DOC16/357994-01

I am writing to you in relation to the proposed expansion of the Hearne St Mortdale Resource Recovery Facility (SSD 7421), from 30,000 tpa to 300,000 tpa. It is also proposed to permit waste movements in and out of the facility 24 hours per day.

ATTACHMENT A – Comments for Proponent

STORMWATER MANAGEMENT SYSTEM

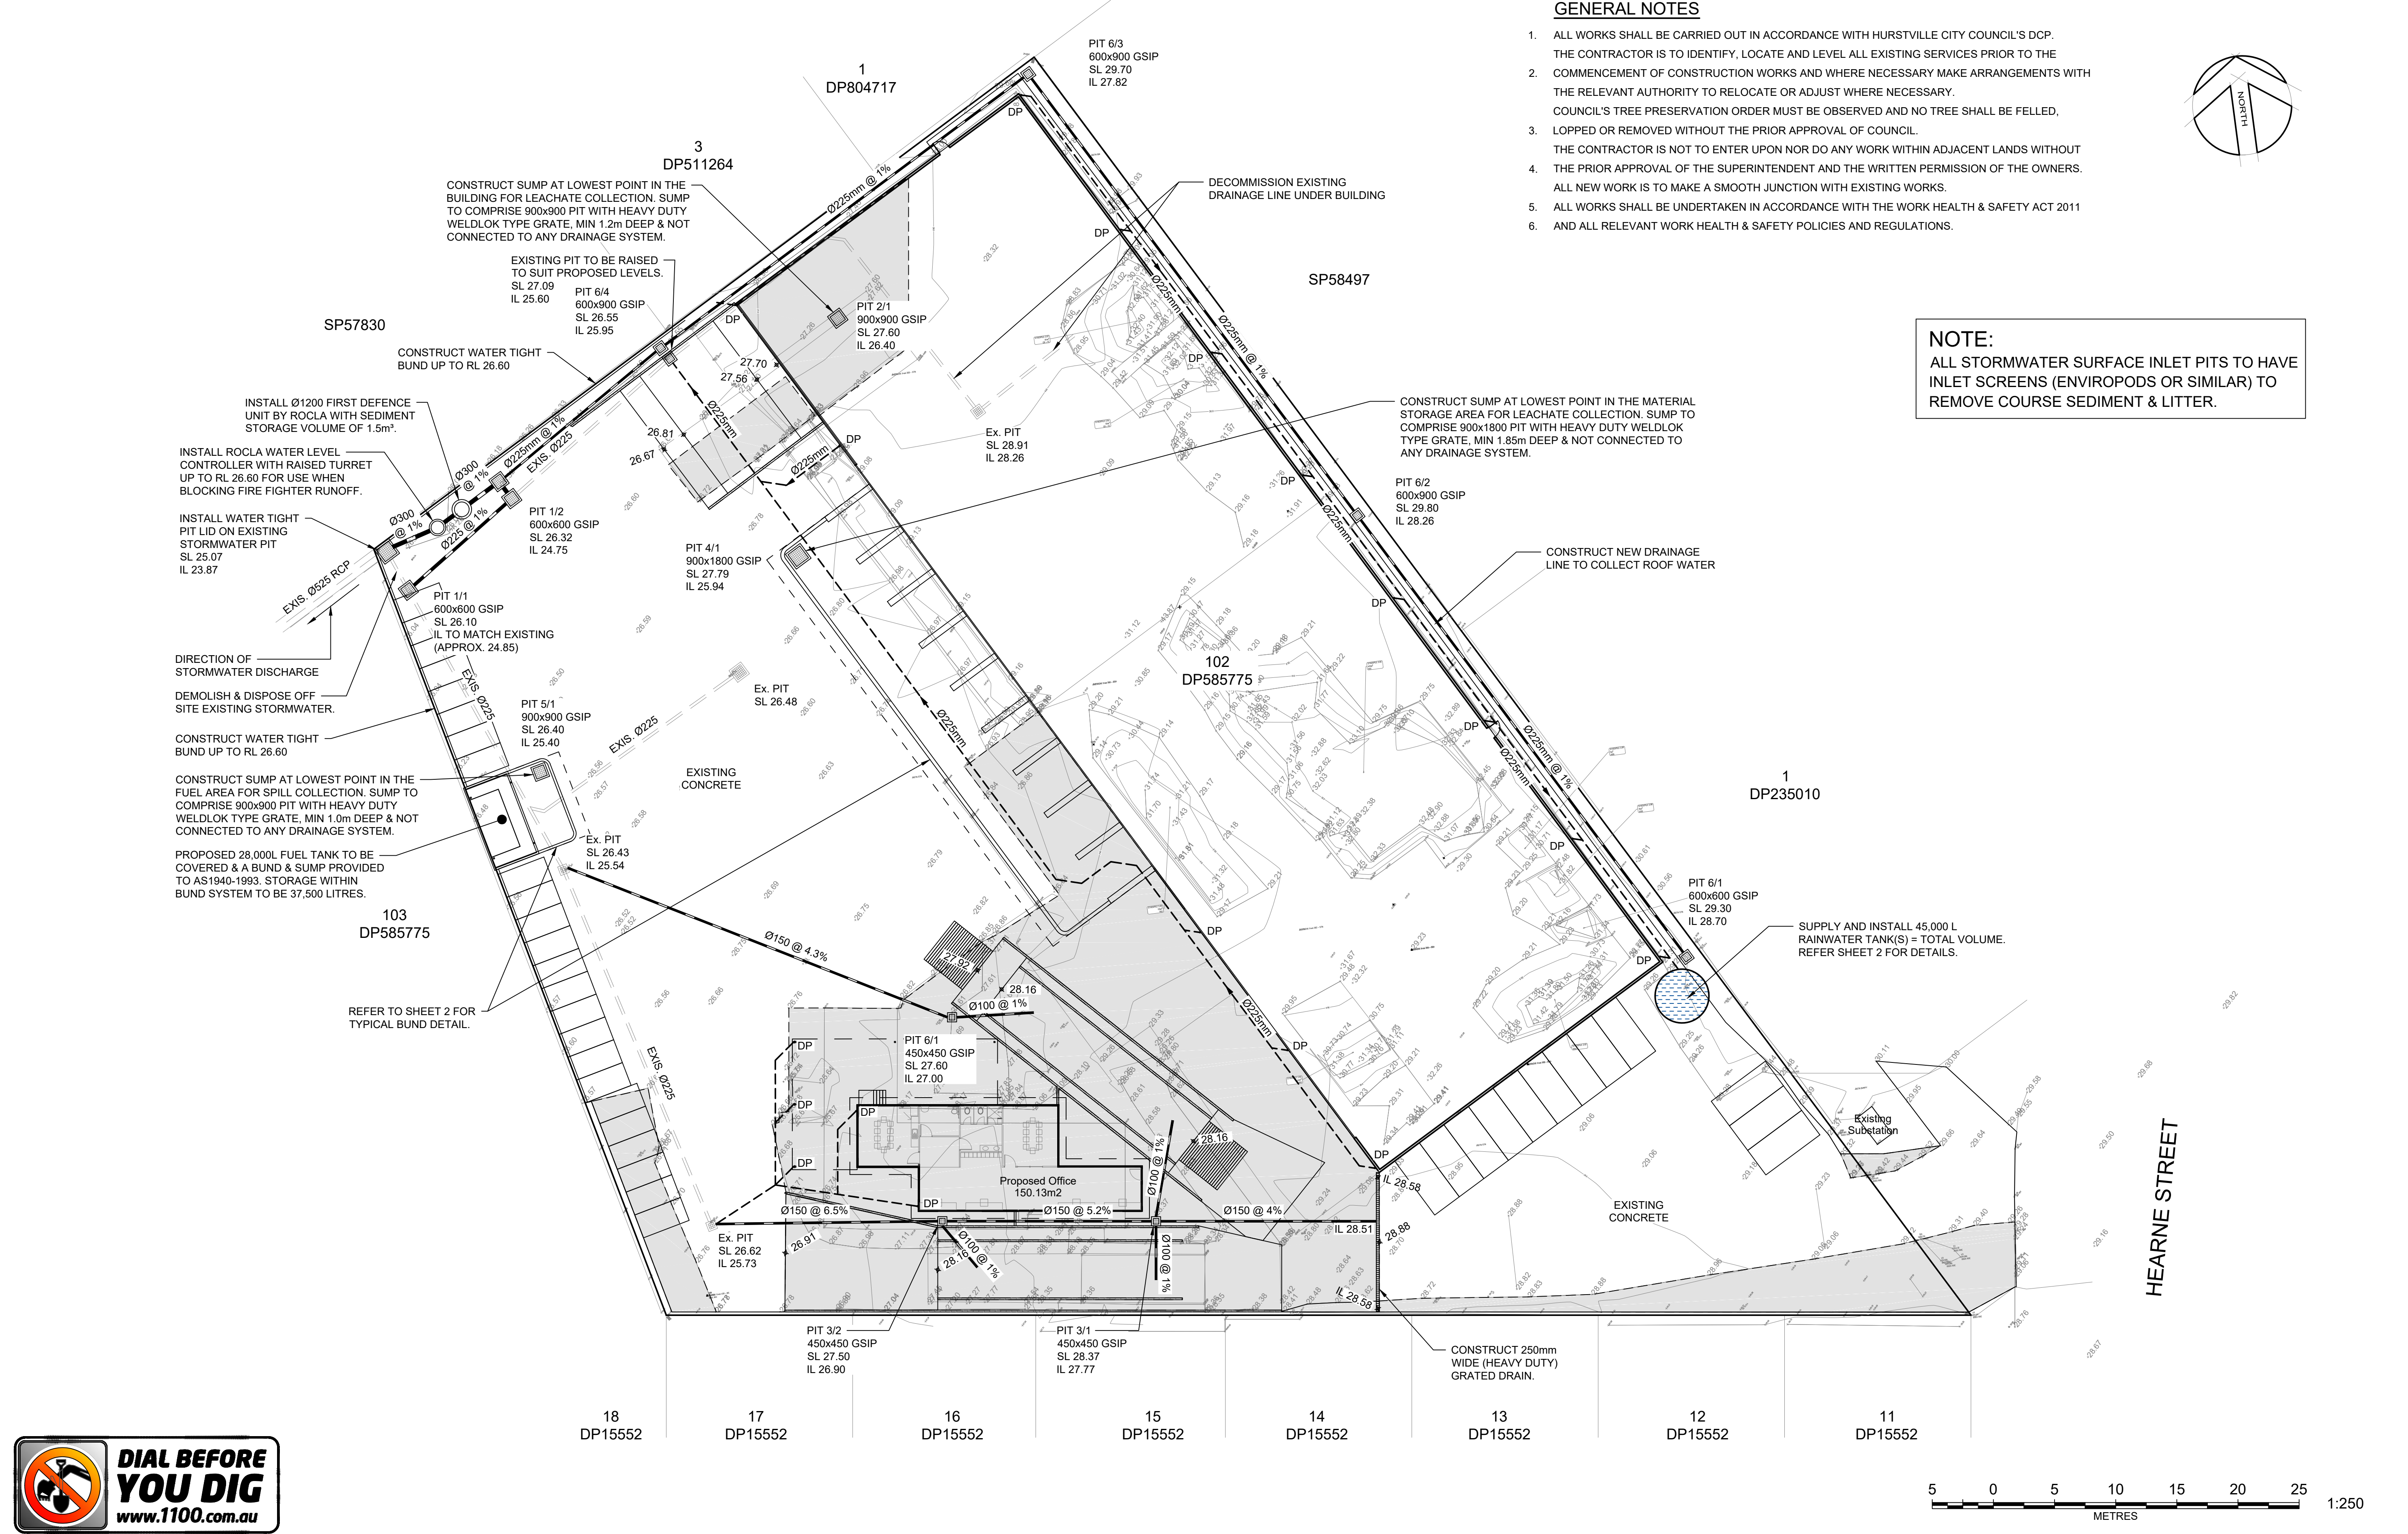
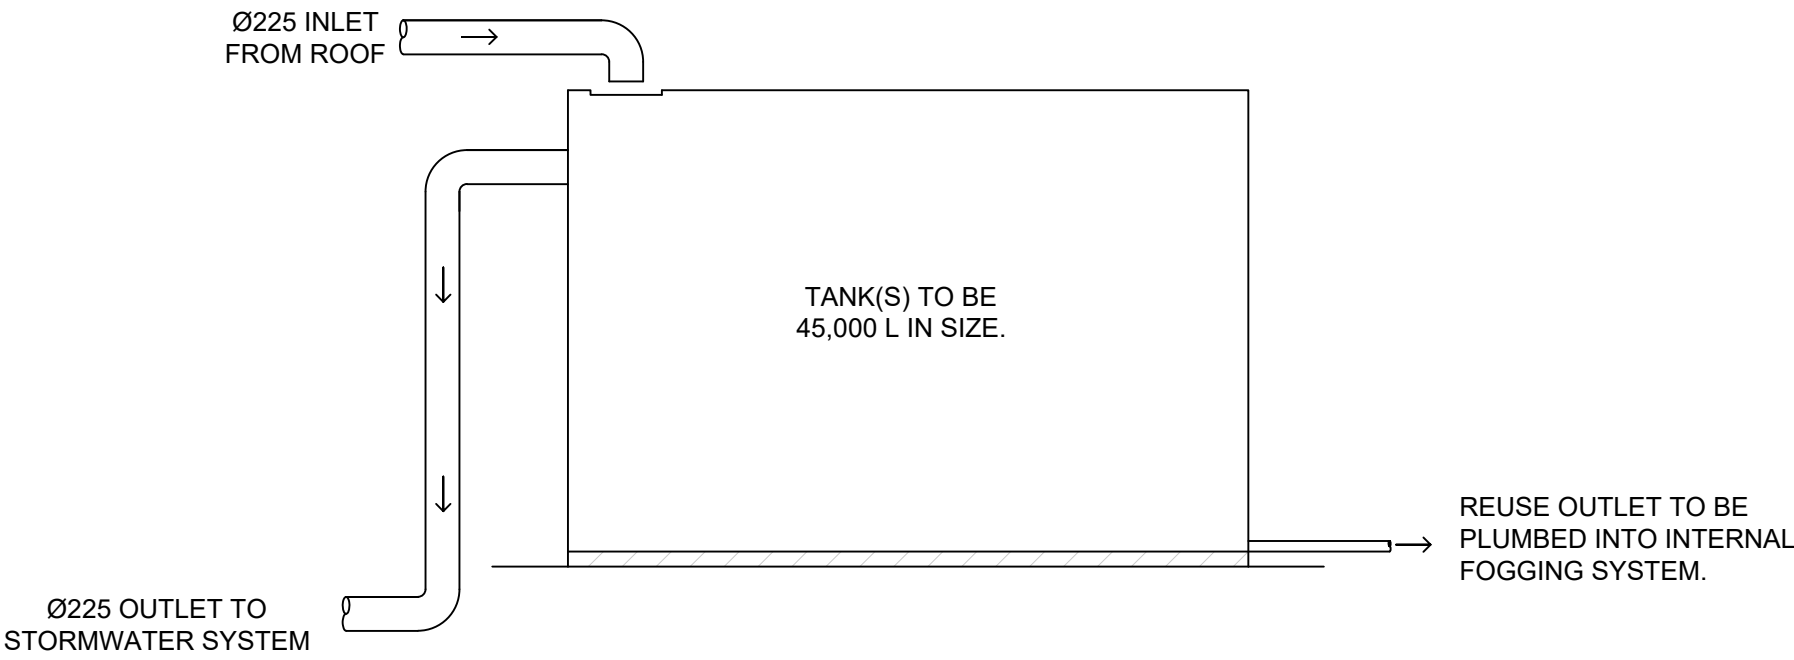
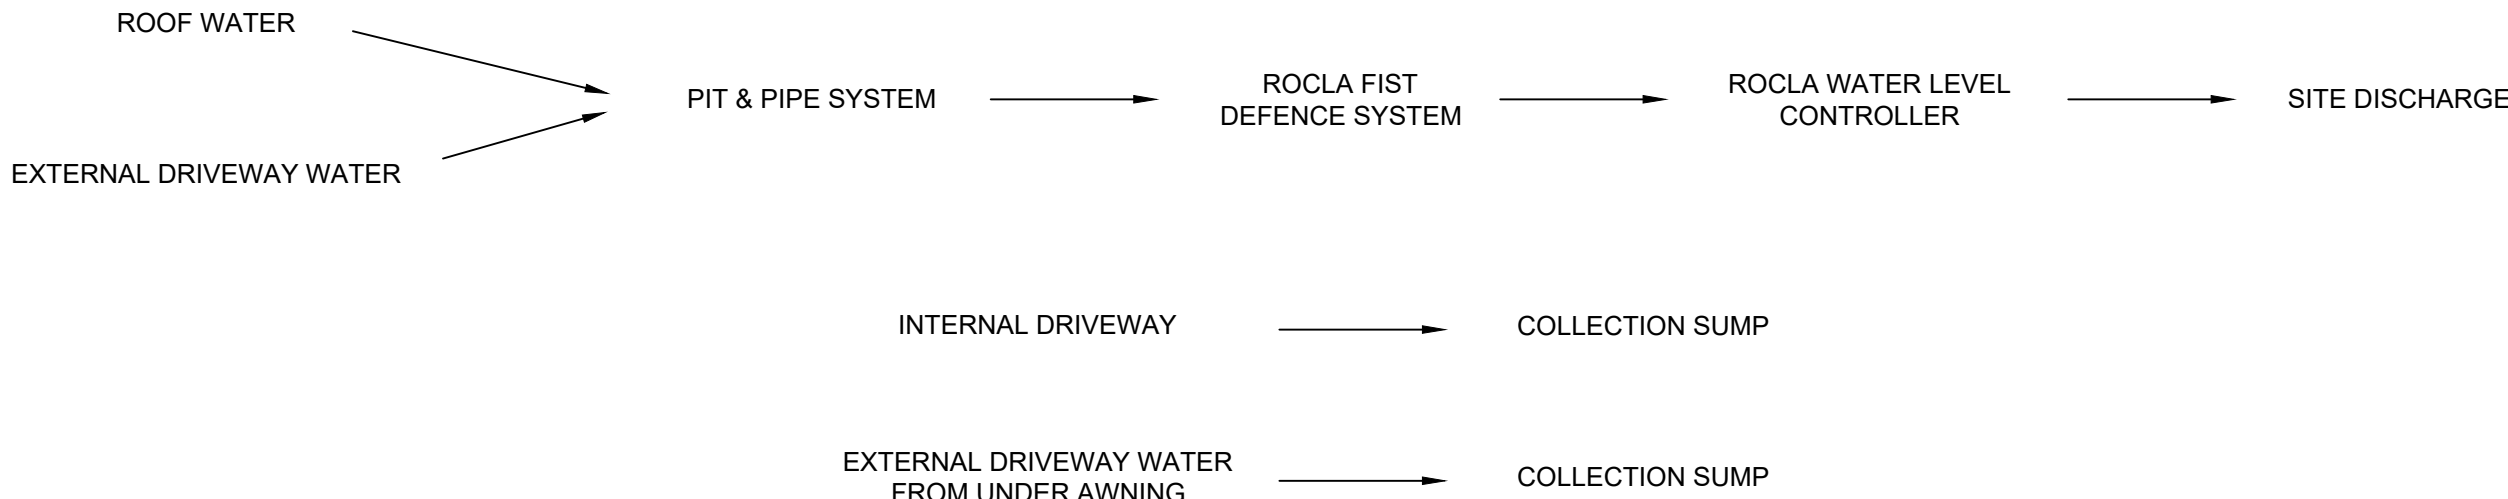
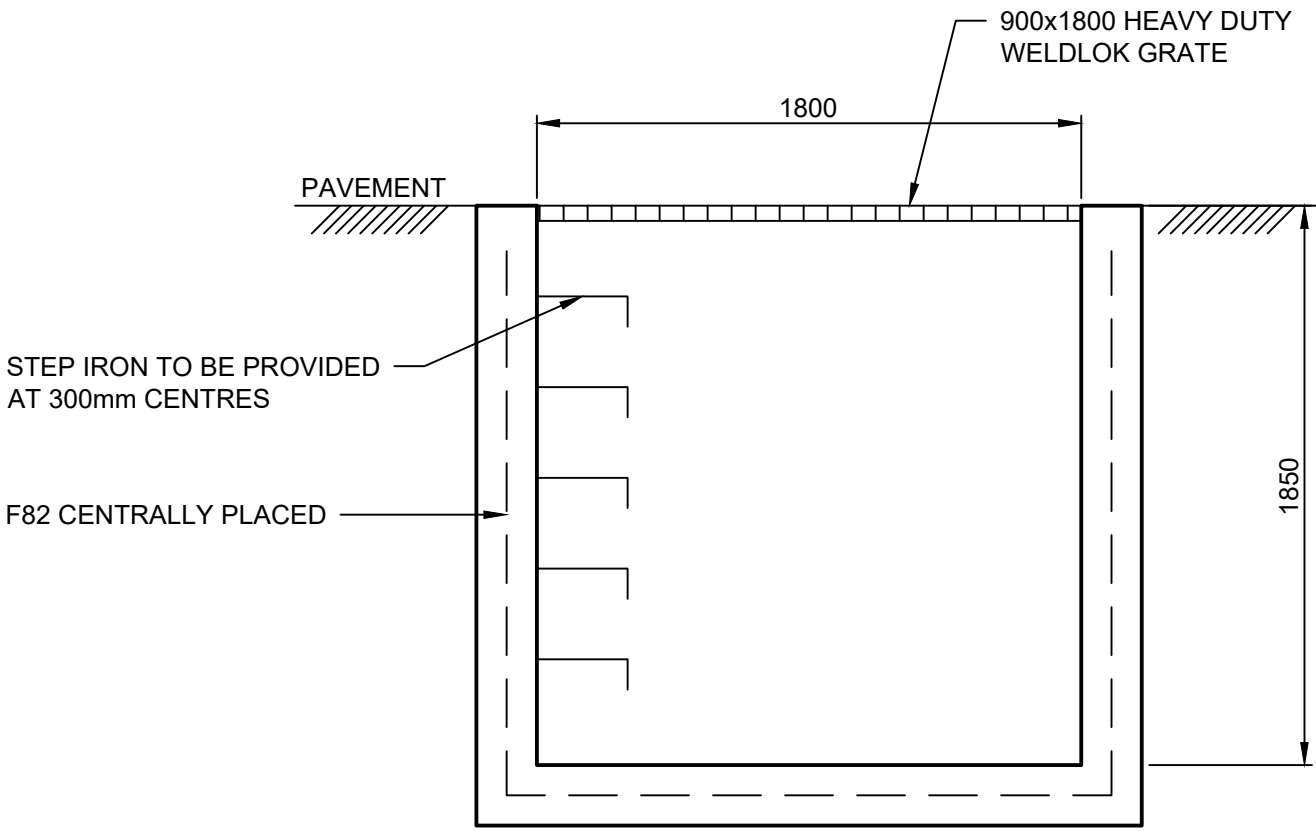
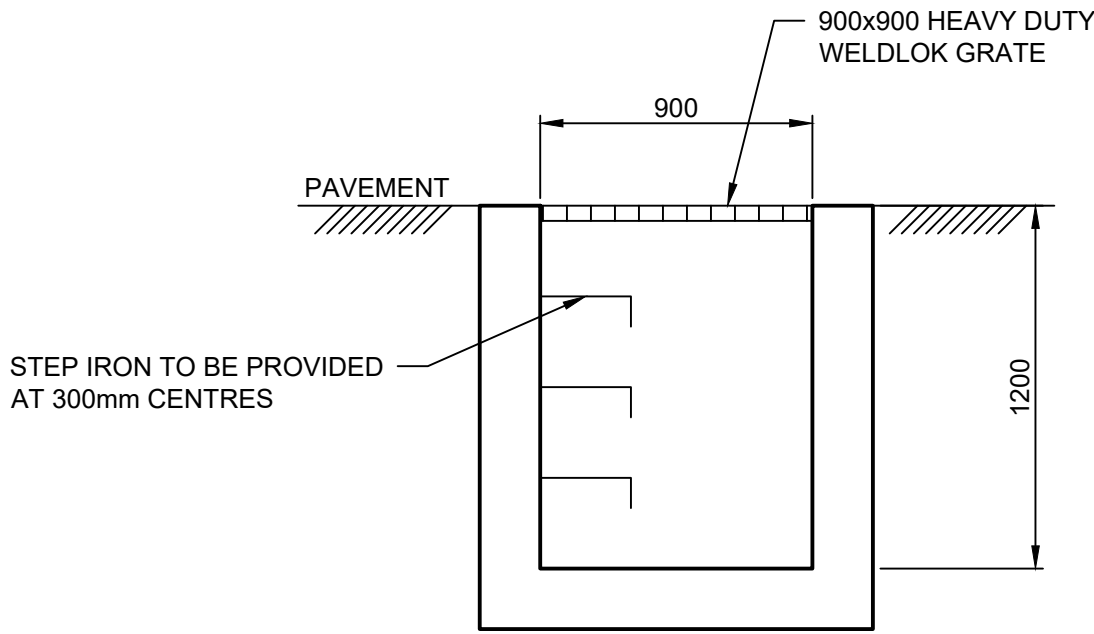
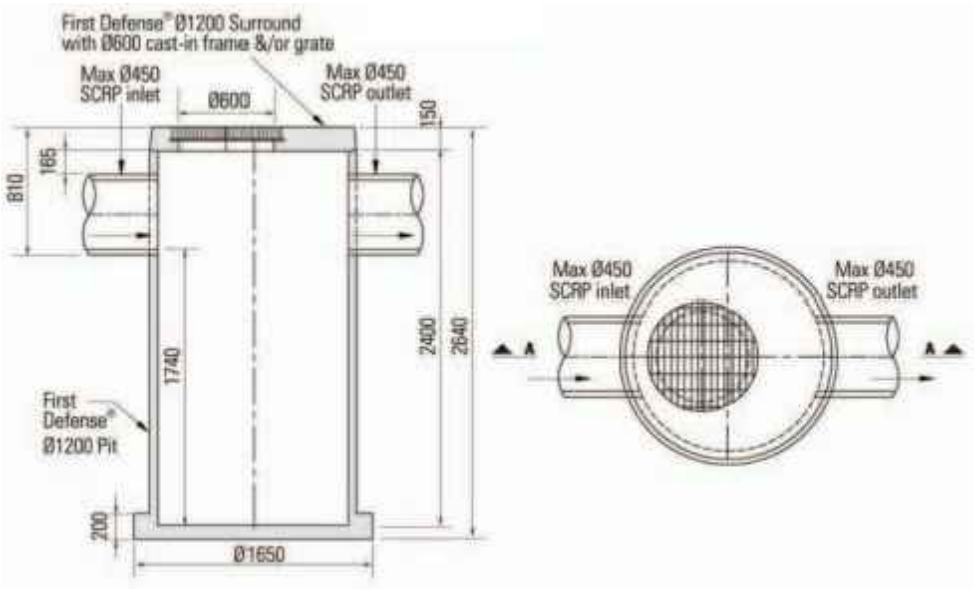
The EPA notes that the Proponent has proposed that all leachate will be collected in sumps to prevent contamination of stormwater, but the Proponent has not specified how this leachate will be disposed of. Prior to the EPA being able to issue conditions of approval, the Proponent must clarify how leachate will be disposed of (e.g. discharge to sewer).
